Aighton Bailey and Chaigley Parish Council
c/o 17 Smithy Row
Hurst Green
Clitheroe
BB7 9QA
Email: clerk@aightonbaileyandchaigley-pc.gov.uk

3rd December 2025

Planning Application No: 3/2025/0758 Grid Ref: 3689024 438046 Proposal: Proposed change of use of agricultural land to four no.1 bedroom holiday lodges, relocation of the site access, improvements to the public footpath and associated landscaping. Location: Land off Whalley Road Hurst Green (adjacent to Reed Deep BB7 9QJ)

Project Name	Land off Whalley Road	Project No.	185.23	Stage	Planning Submission
Proposed site plan	03	Scale	1:500 @ A1	Date	June 2025
Rev A		Drawn	ZM

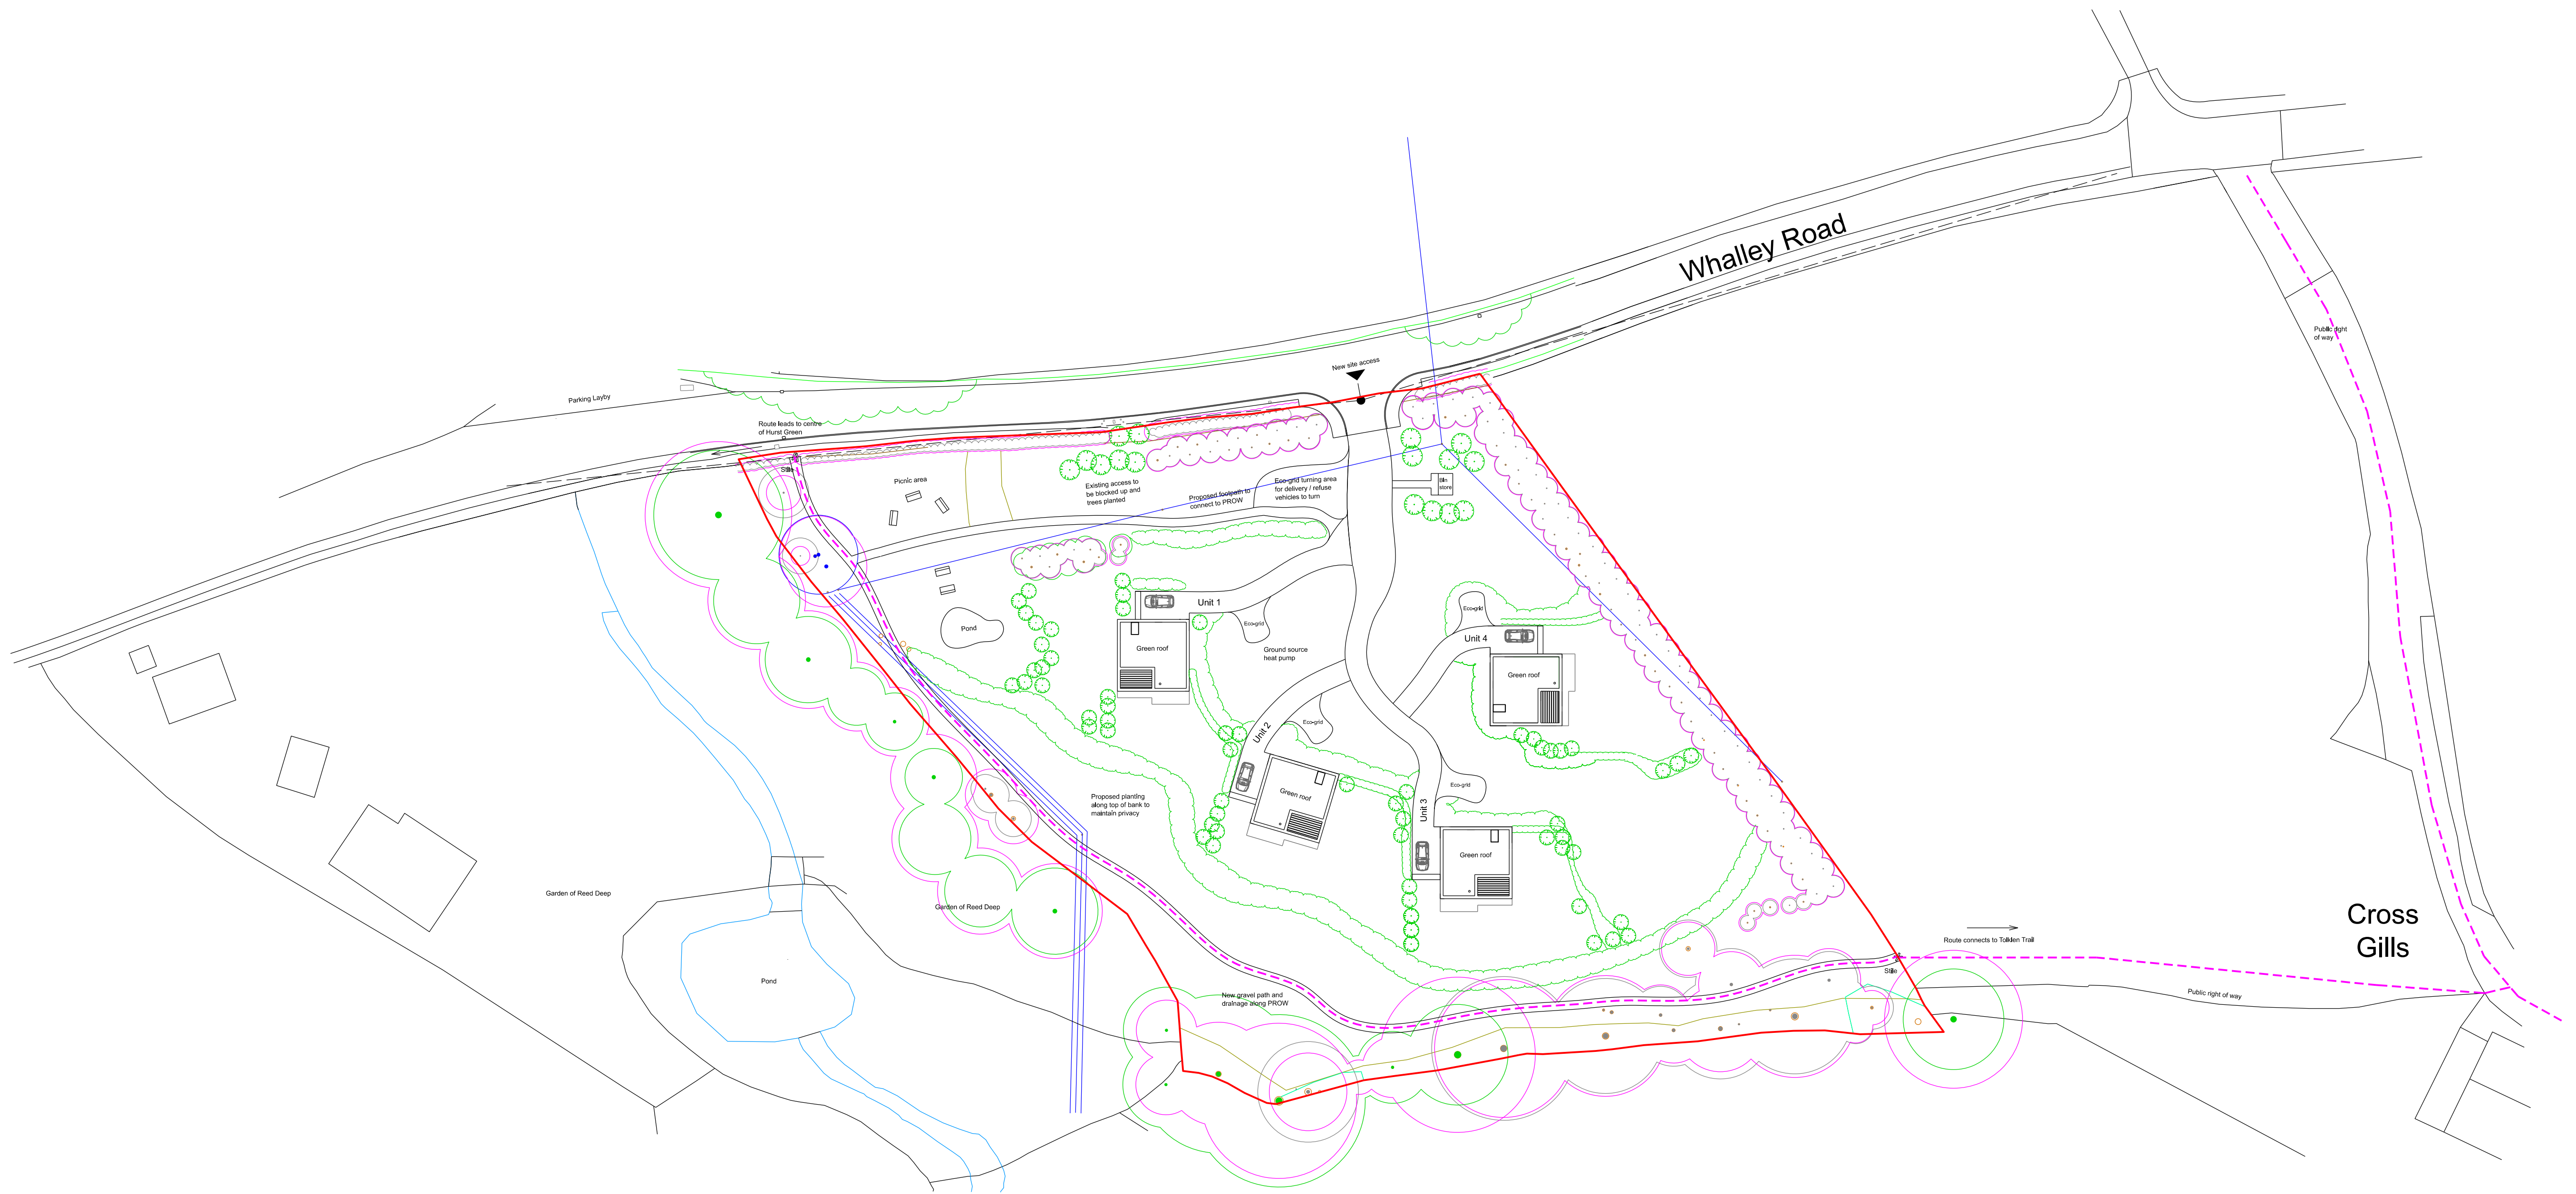
Highways will have a view on the new proposed entrance, but we remain concerned that this is a section of road on a bend and shortly after a hill that is not covered by the 30mph speed limit, but is at National Speed limit, with many vehicles travelling at excessive speeds for the location.
